**RESPONSE TO NOTICE OF MODIFICATION TO SSD 6076 (MOD 2) 4 MURRAY ROSE AVE,
SYDNEY OLYMPIC PARK**

I refer to your letter dated 9 February 2017 regarding the above application. Sydney Olympic Park Authority (the Authority) has reviewed the submitted application and wishes to raise the following in relation to the proposed development.

CARS	SMALL CARS	ACCESSIBLE	TOTAL
BASEMENT 01	42	28	0	70
BASEMENT 02	36	38	8	82
BASEMENT 03	53	41	0	94
TOTAL	131	107	8	246
MOTORBIKES				21
BICYCLES (VISITOR)				105
BICYCLES (VISITOR)				22

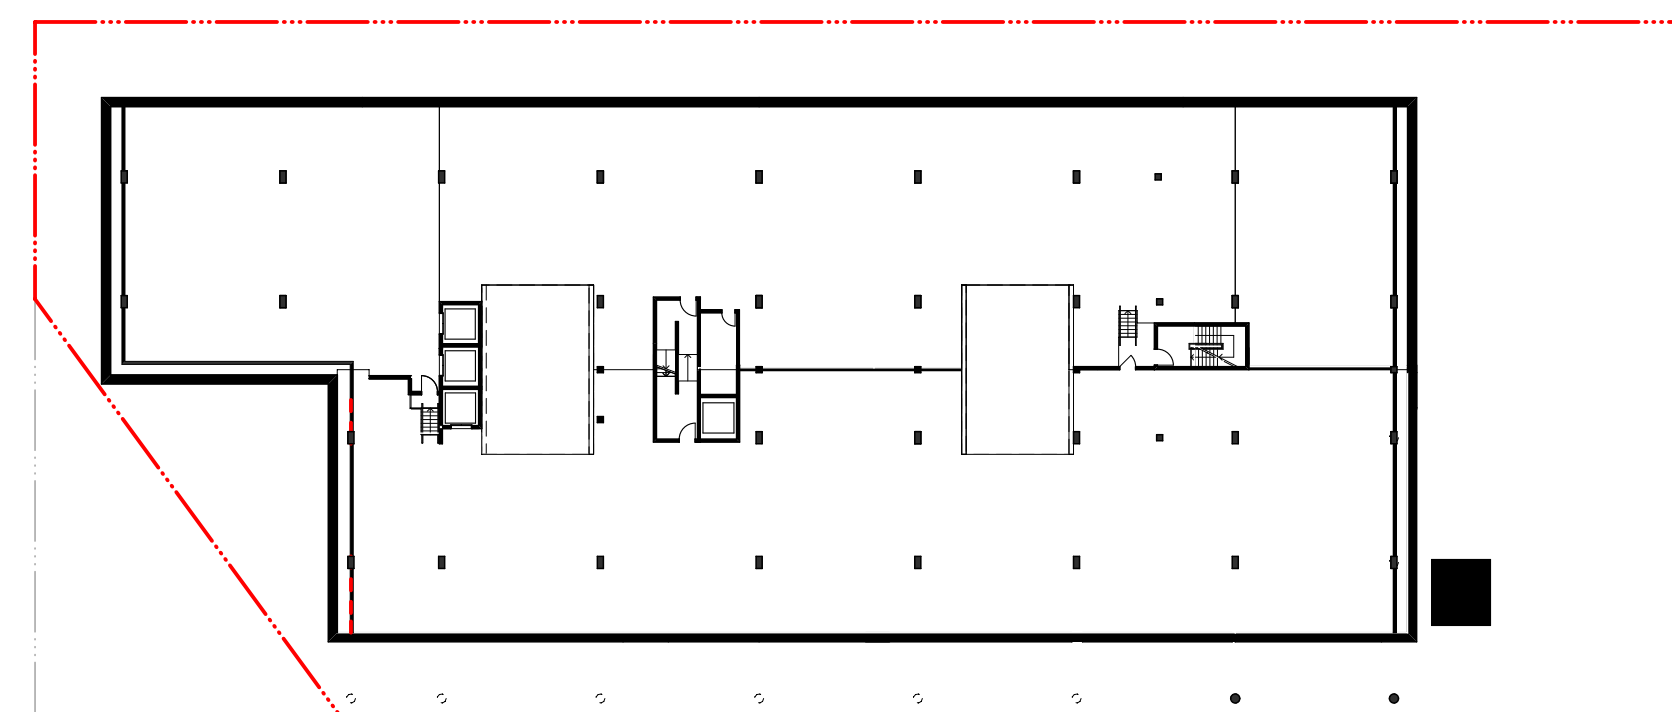
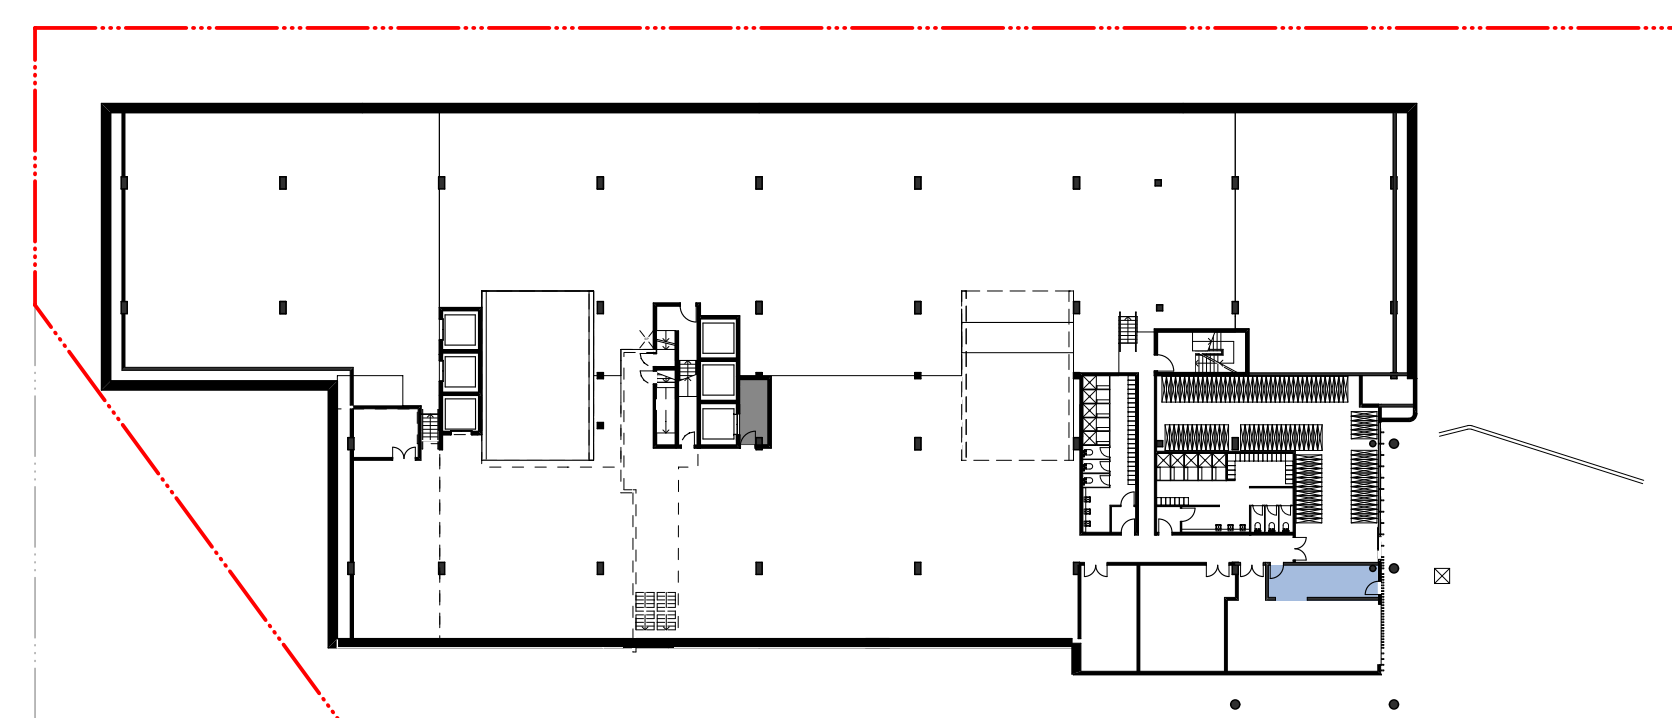
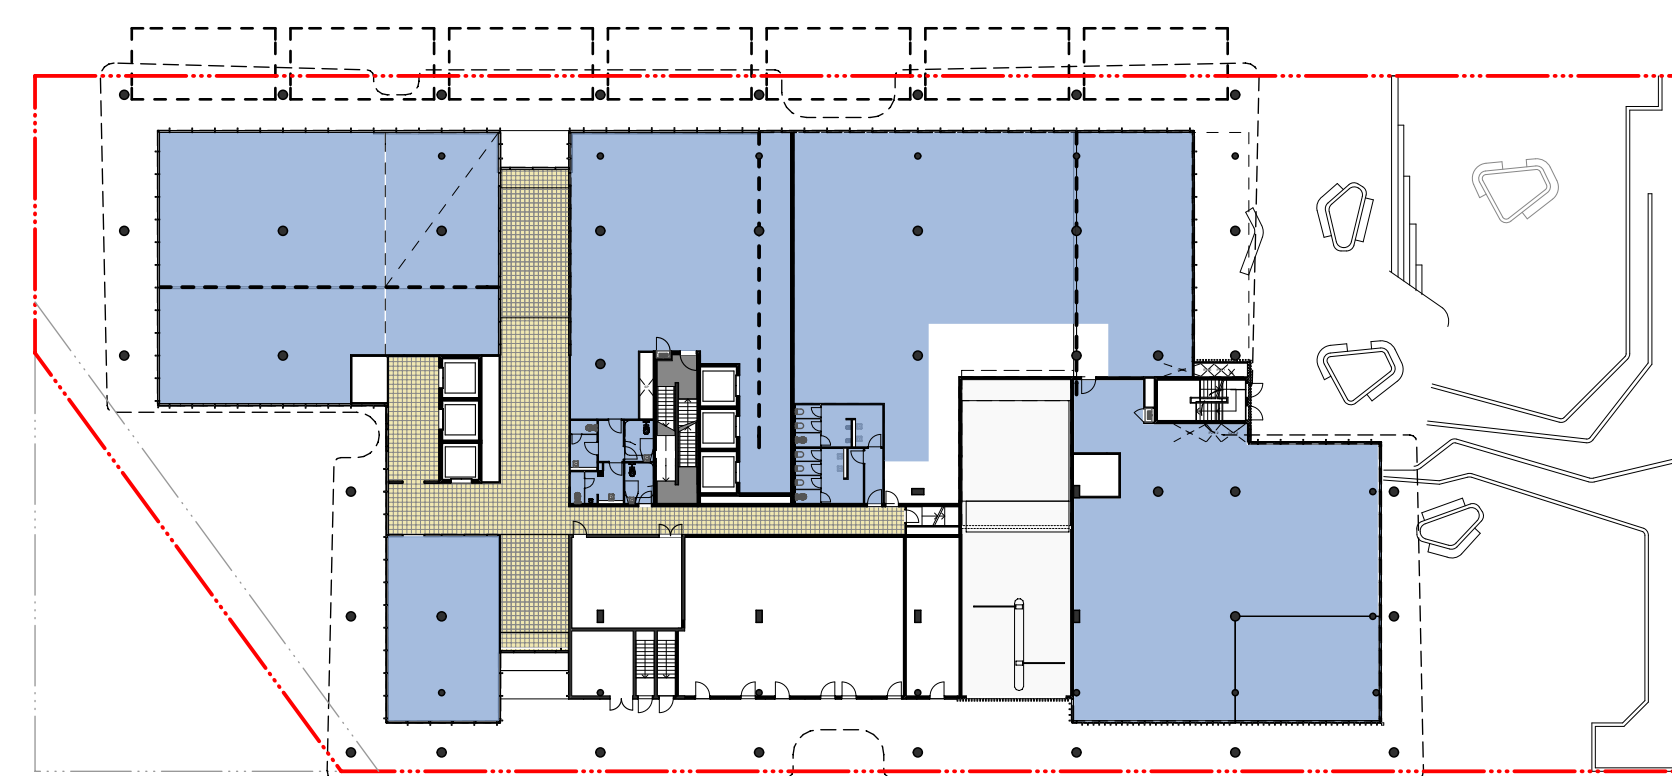
The Authority notes that the level of car parking is proposed to be reduced. It is recommended that the Department ensures that the resultant parking numbers remain compliant with the current Sydney Olympic Park Authority Access Guidelines, which requires a minimum of 2% accessible spaces.
